From: Natalie McKellar [REDACTED]
Sent: 05 November 2020 11:26
To: Simon Davis <Simon.Davis@arun.gov.uk>
Subject: RE: Springfield, Hook Lane, AL/64/20/PL - Drainage

From: Simon Davis
Sent: 03 November 2020 17:33
To: Natalie McKellar [REDACTED]
Cc: Kerry Simmons [REDACTED]
Subject: Springfield, Hook Lane, AL/64/20/PL - Drainage

Drainage Strategy				Draining The
Engineering Details				
Drawn	Checked	Scales	Paper Size	Date
JN		1:250	A1	08.19
Job No.				Revision
KNC/1932	602-01			C

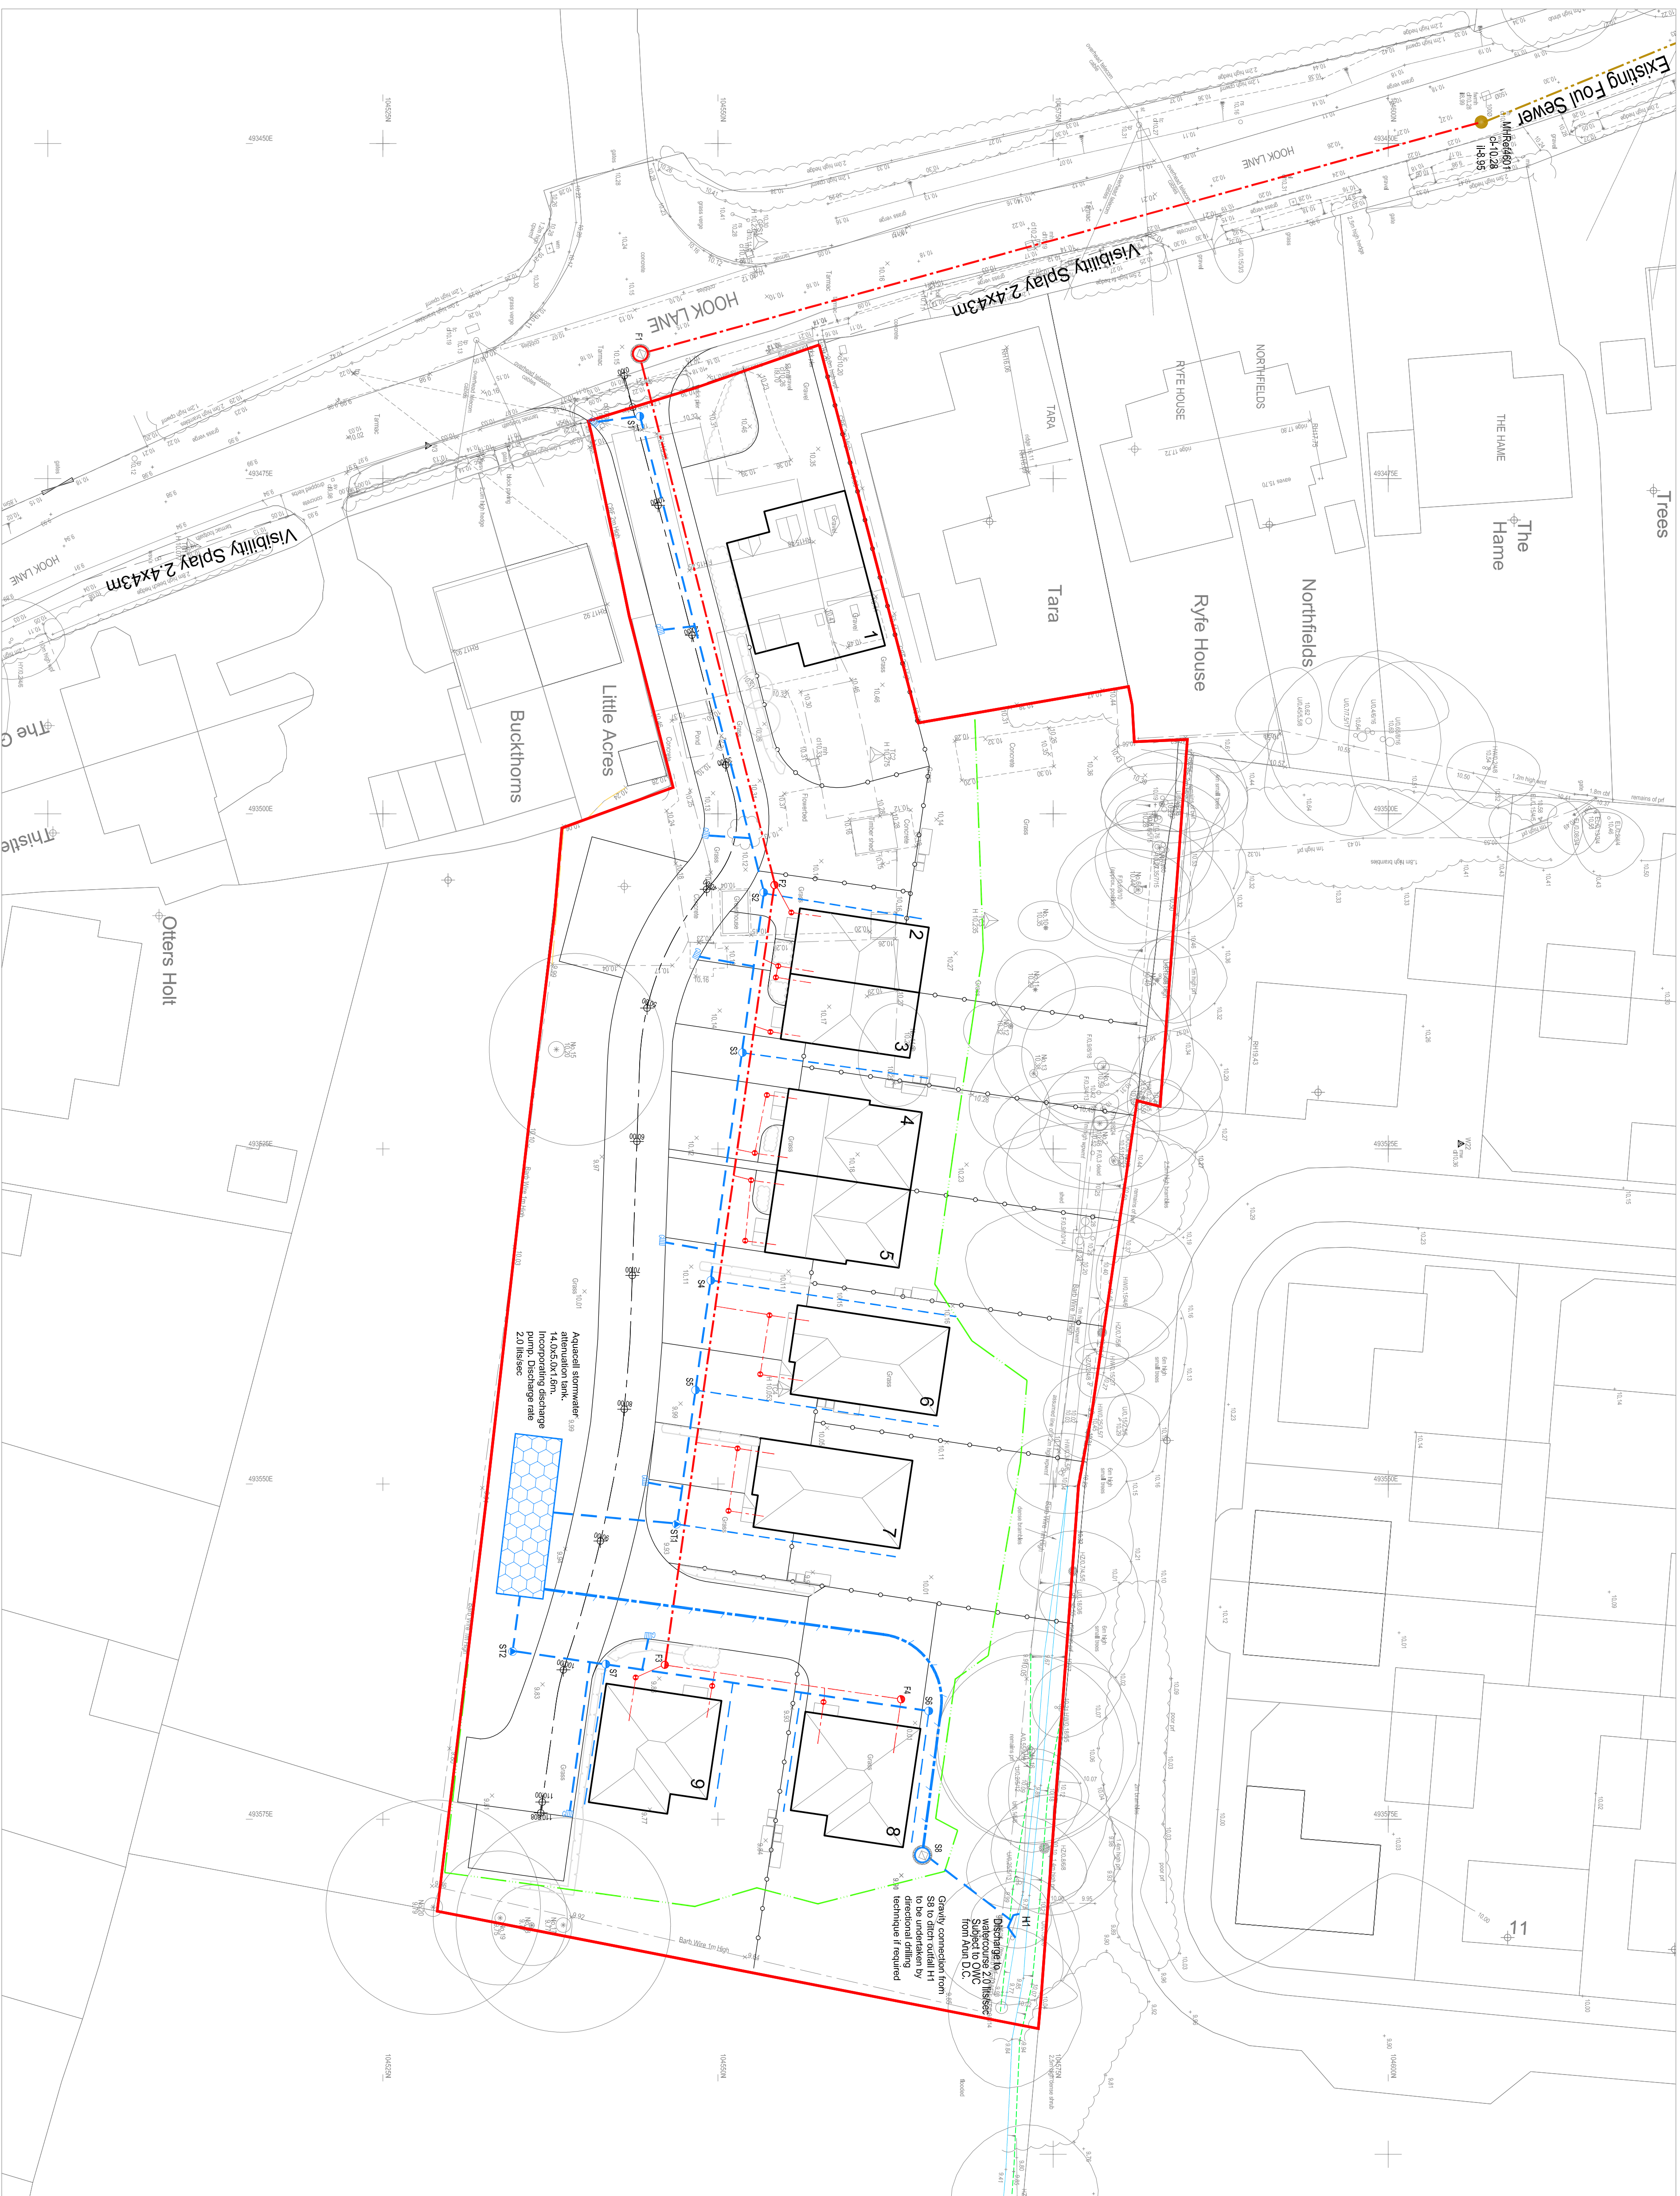
I write separately to my two emails today. I wonder did you note the drainage comments on our website as received 13/10/20? I initially missed these but if you review them, you'll see that they request that boundary fences are kept at least 3 metres away from the banks of the northern boundary ditch in order to allow for future. They also request that the true extent of the ditch is established to take account of recent works undertaken by BDW. They state this matter must be resolved before the layout is agreed.

I am proposing to deal with this through an amended version of the standard boundary treatments condition:

No development above damp proof course (DPC) level shall take place until details of all new screen walls and fences have been submitted to and approved by the Local Planning Authority and none of the approved dwellings shall be occupied until such screen walls/fences associated with them have been erected. The submission of such details shall include an up-to-date survey of the ditch running along the northern boundary to take account of recent works to it as undertaken by Barratt David Wilson in respect of the adjacent site; and also the measures required to ensure 3m easements from the opposing banks of this ditch including the use of demountable fencing where appropriate.
